KIRKLEES METROPOLITAN COUNCIL INVESTMENT & REGENERATION SERVICE

DELEGATED DECISION TO DETERMINE PLANNING APPLICATIONS

Reference No:	2026/62/92290/W
Site Address:	38, Grange Avenue, Marsden, Huddersfield, HD7 6AQ
Description:	Formation of patio and steps
Recommending Officer:	Joshua Merriman

Officer Report – 2026/92290

Proposed sectional/north facing elevation (1:100)

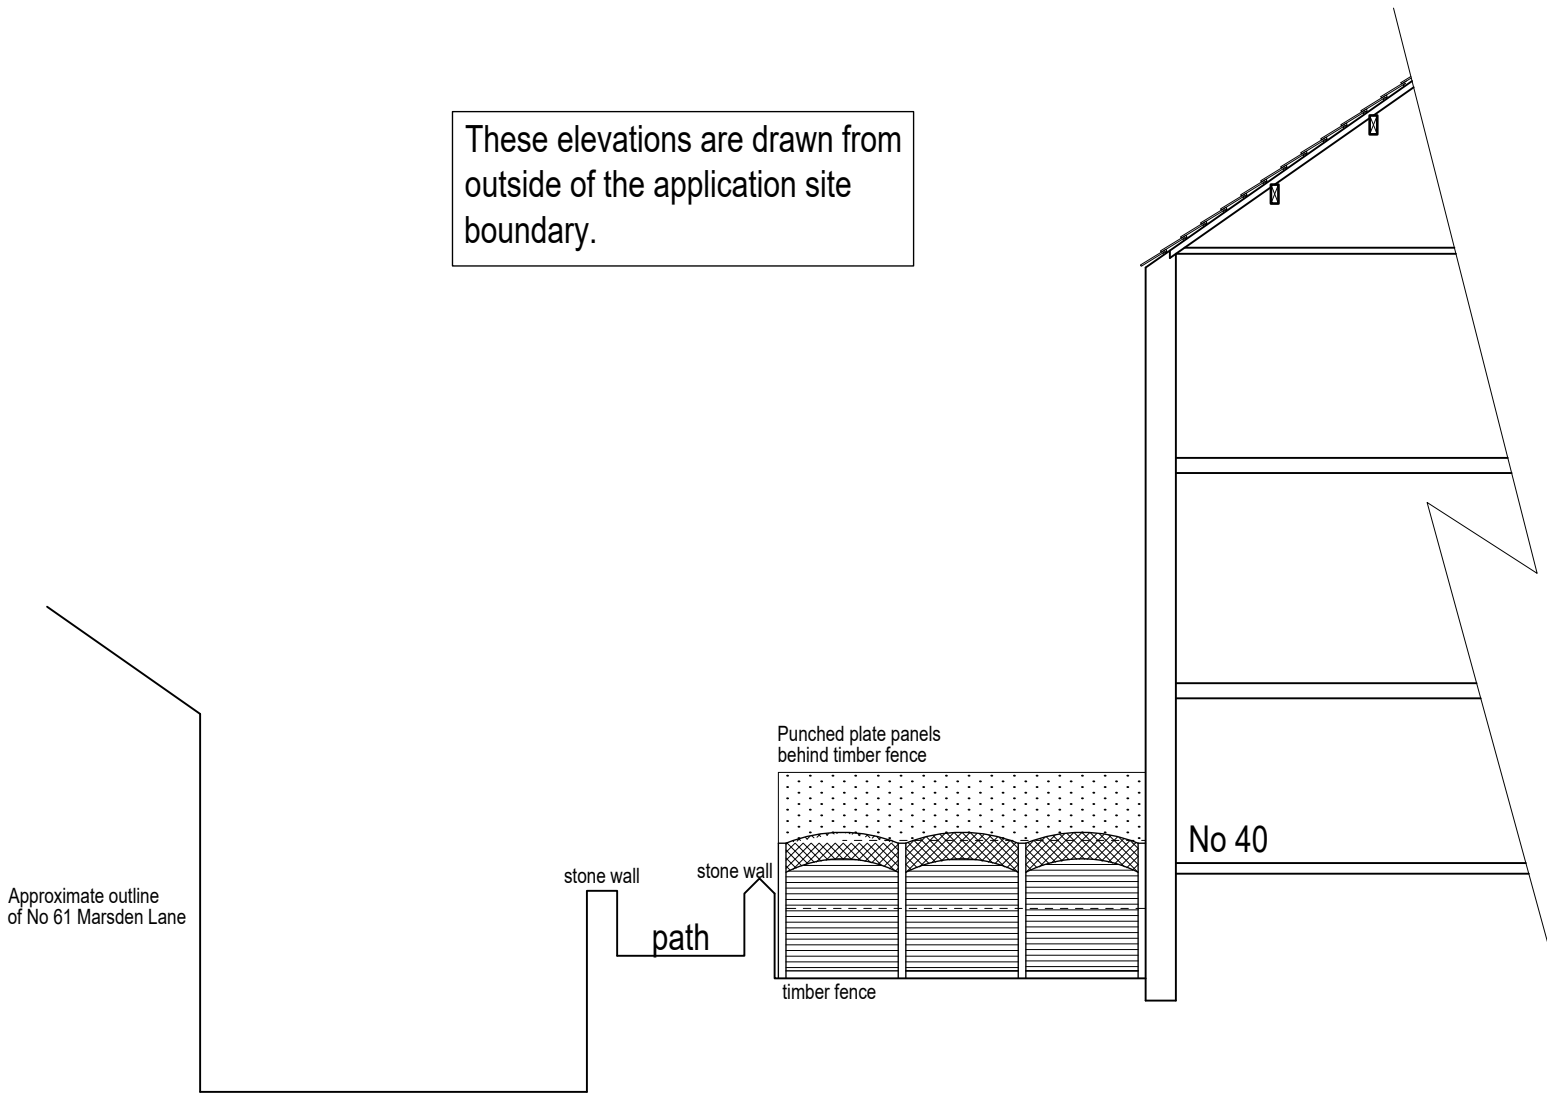
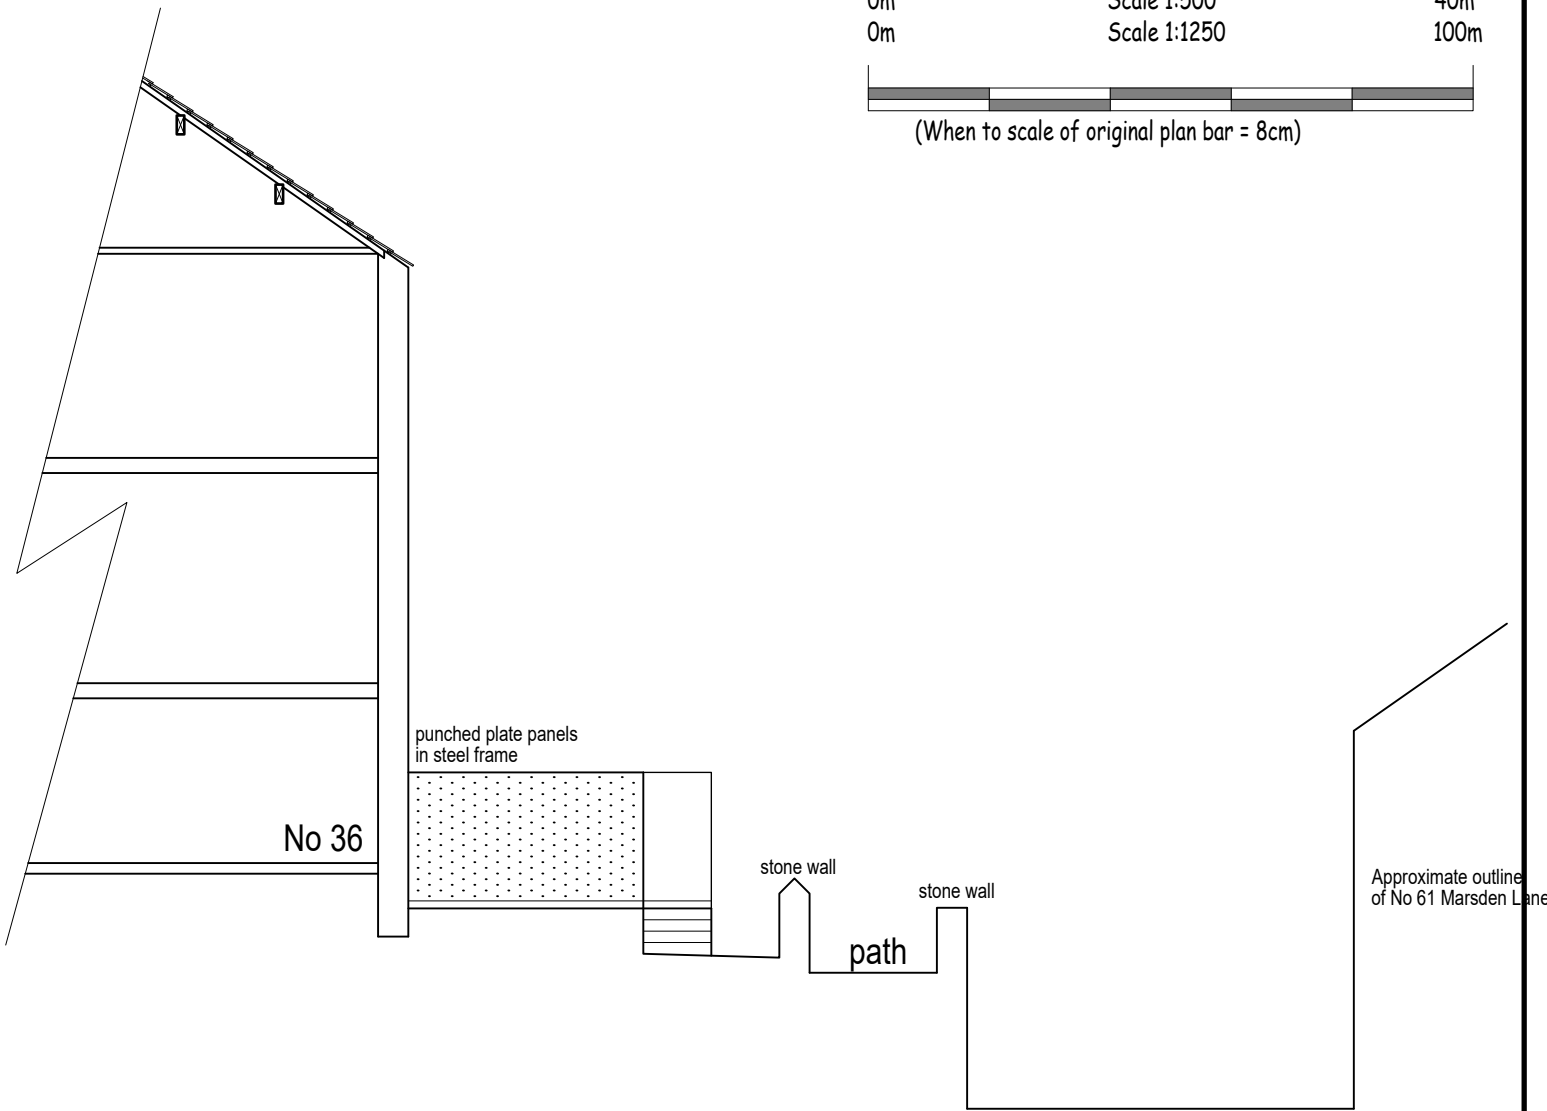
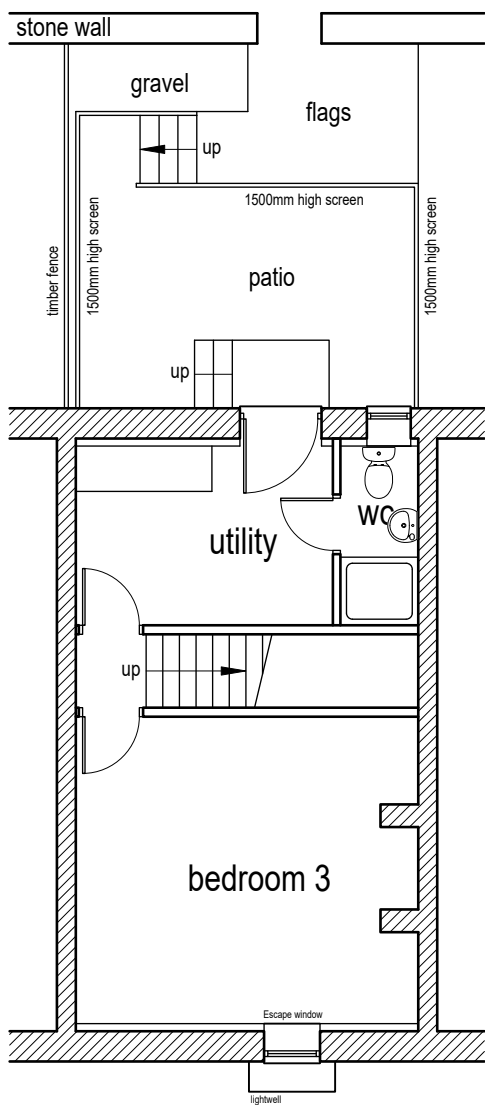
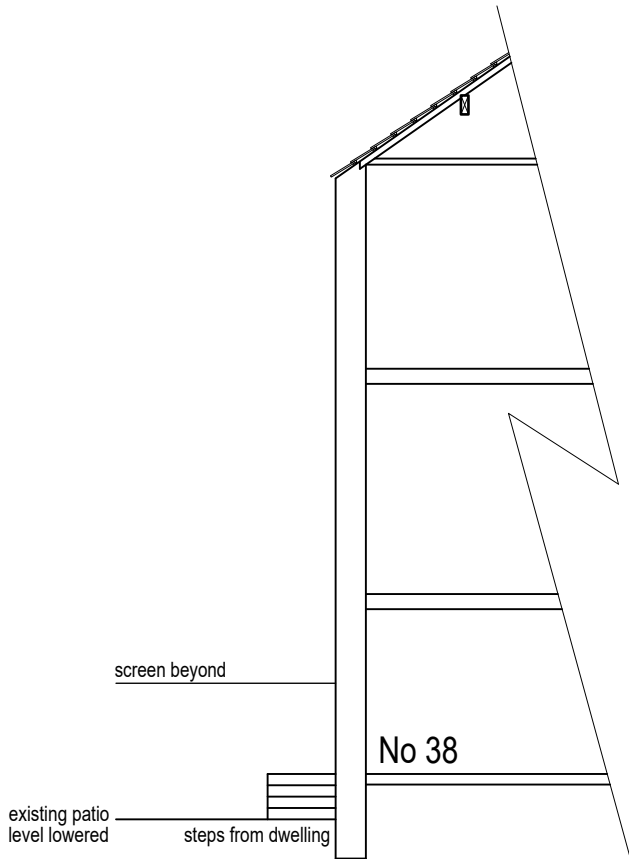
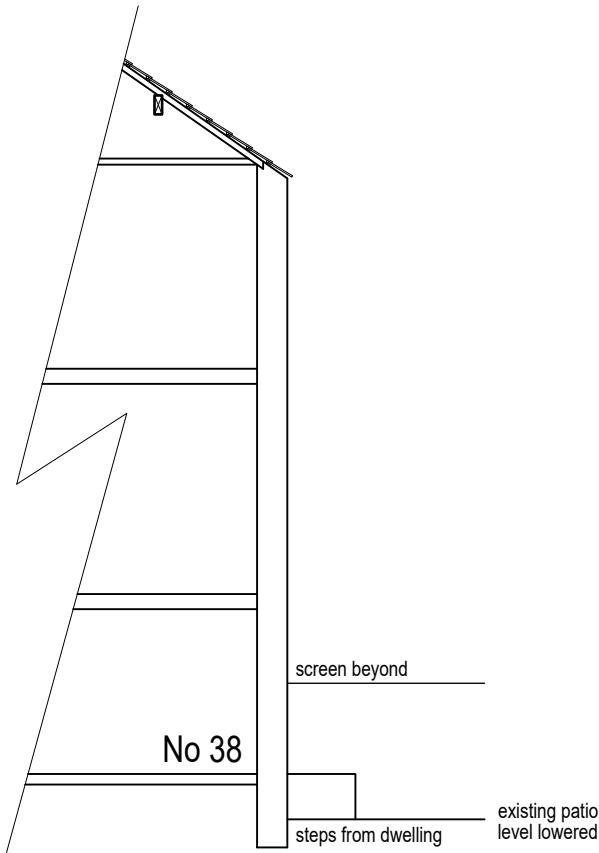
Officers requested the use of a 1.8m high privacy screen to the boundaries of the proposed patio, ensuring that concerns regarding overlooking and privacy did not remain from the previous refusal 2026/91456, and these reasons for refusal were completely overcome regarding overlooking and privacy.

As the amended patio area has been decreased in height, and contains privacy screens at 1.8m in height, it is considered that the overlooking and privacy impacts outlined within previous application 2026/91456 have been overcome, as the privacy screens would prevent overlooking from this area of the application site.

2. Prior to the occupation of the development, the obscure glazed screens surrounding the patio hereby approved should be erected at a height of 1.8m, and shall thereafter be retained.
